**Washington State
Department of Transportation**

Subject: CU-15-00002/SD-15-00001/SP-15-00001, Teanaway Ridge LLC
SR 10 milepost 88.48 Right

We have reviewed the proposed project and have the following comments.

DESCRIPTION:
A 28' PRIVATE ROAD CROSSING SHOWN SHADED.

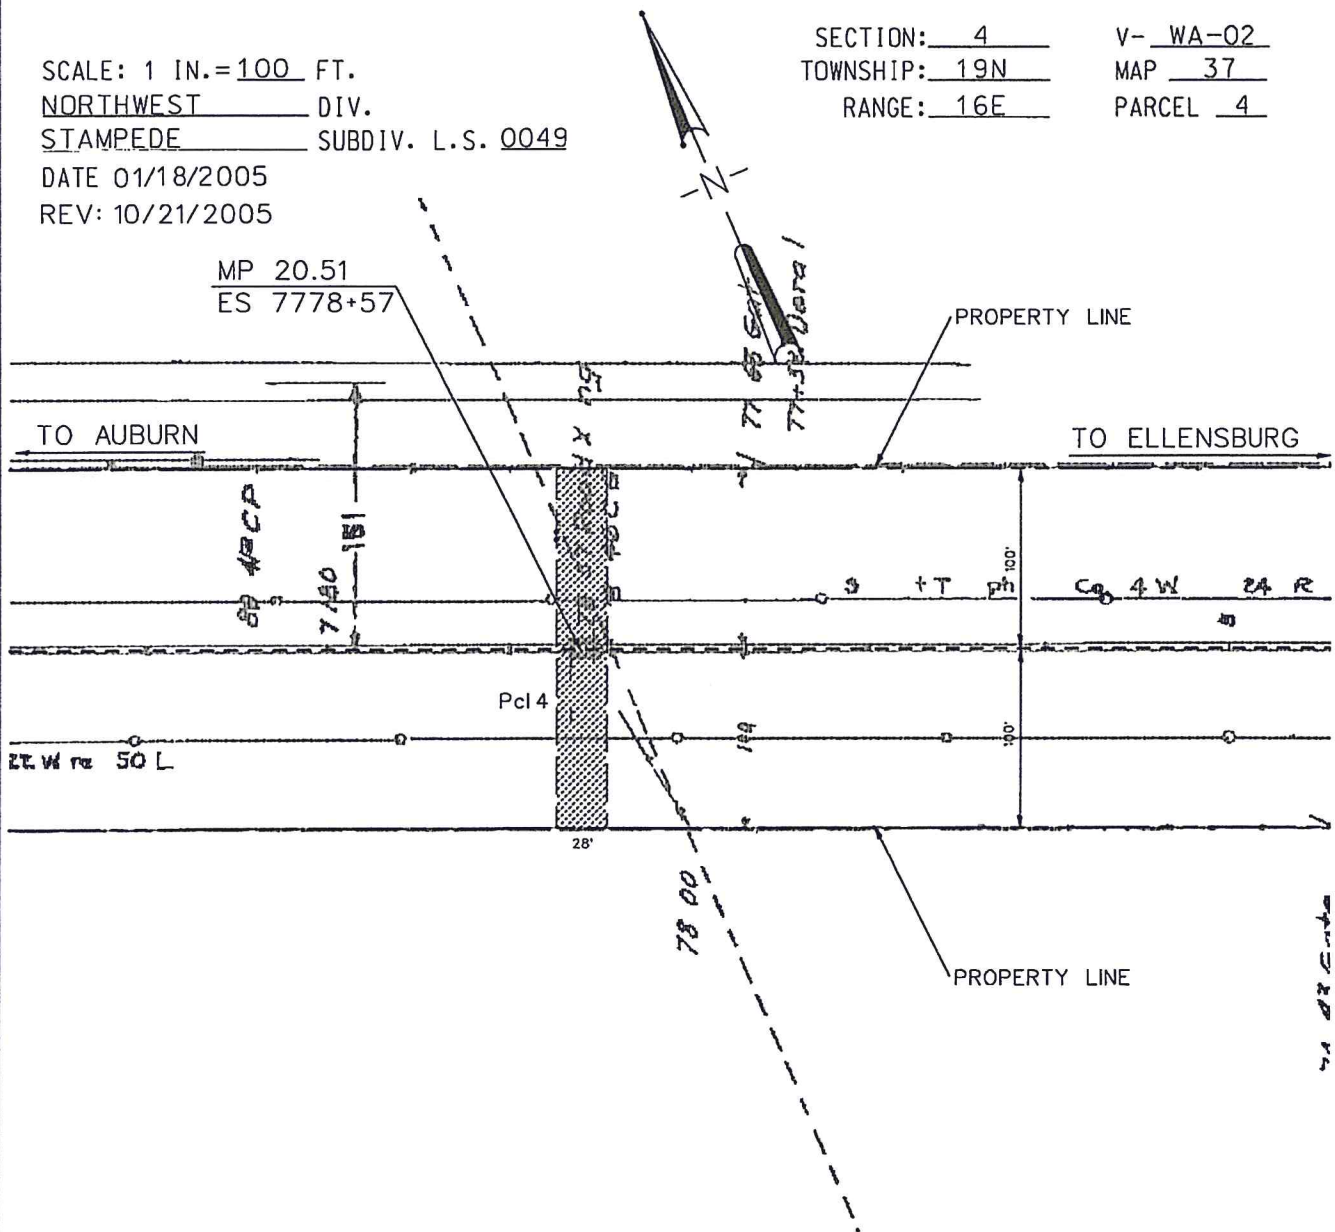
- The subject property is adjacent to State Route 10 (SR 10). This segment of SR 10 is a Class 3 managed access highway with a posted speed limit of 55 miles per hour. There is an existing permitted approach at the west corner of the property at milepost 88.48. WSDOT will continue to allow access for increased use, subject to the BNSF rail crossing permit.
- The proponent is required to contact Mark Kaiser at 509-577-1668 to update the Access Connection Permit. WSDOT also requires that the existing gravel approach be paved as part of updating the permit.
